Department of Environmental Health

December 12, 2007

Re: Status of Improvement Permit Application #07-5-18901
Lot 39 Patton's Point

236 Fifty Caliber Drive  
Lot 39 - Patton's Point Subdivision  
D.B. 2177, Pg. 584 & M.N. 2005-903  
PIN #8897-30-1823.000

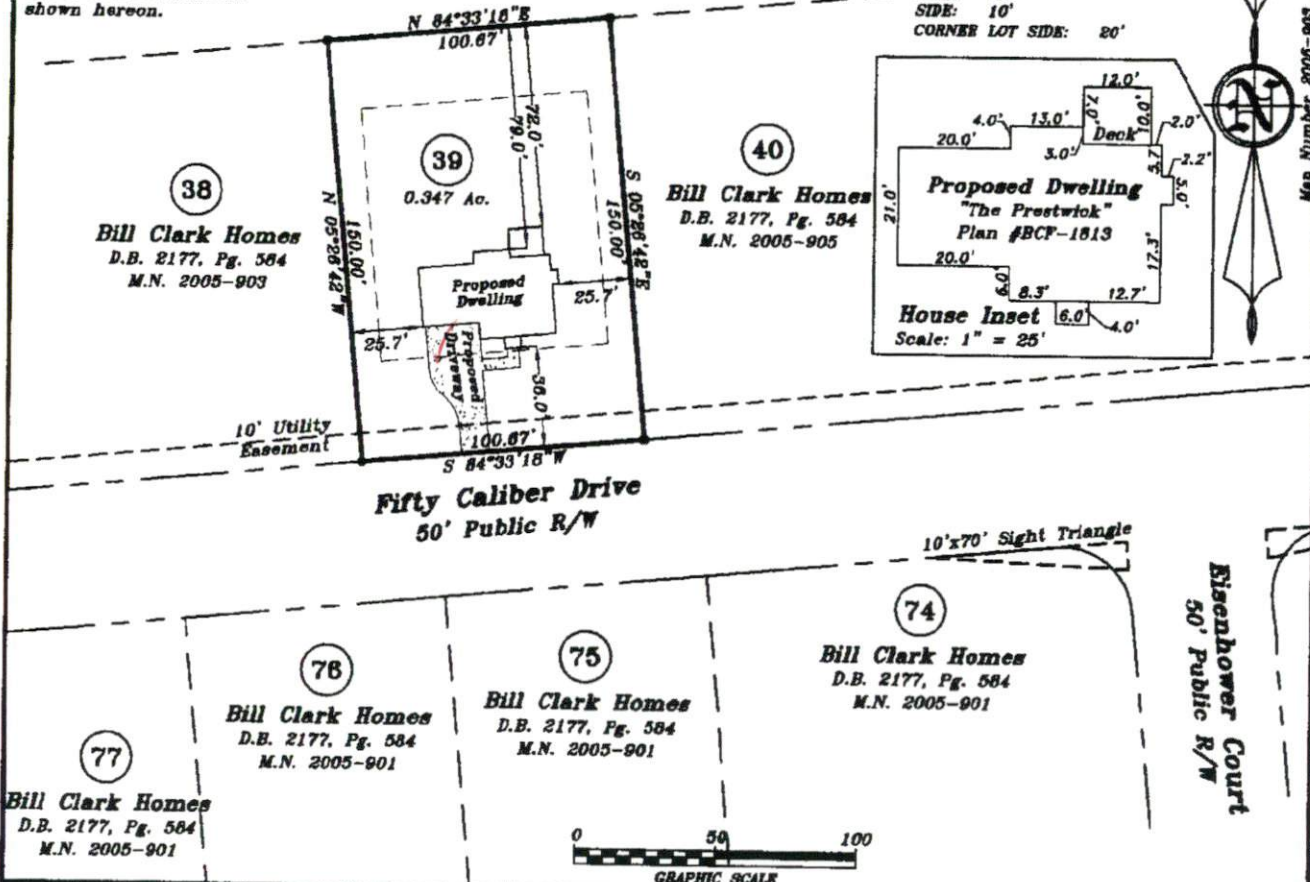
6. Other -I need to meet your consultant on this lot. The house location will need to change and proposed repair system will require a design by a licensed soil scientist.
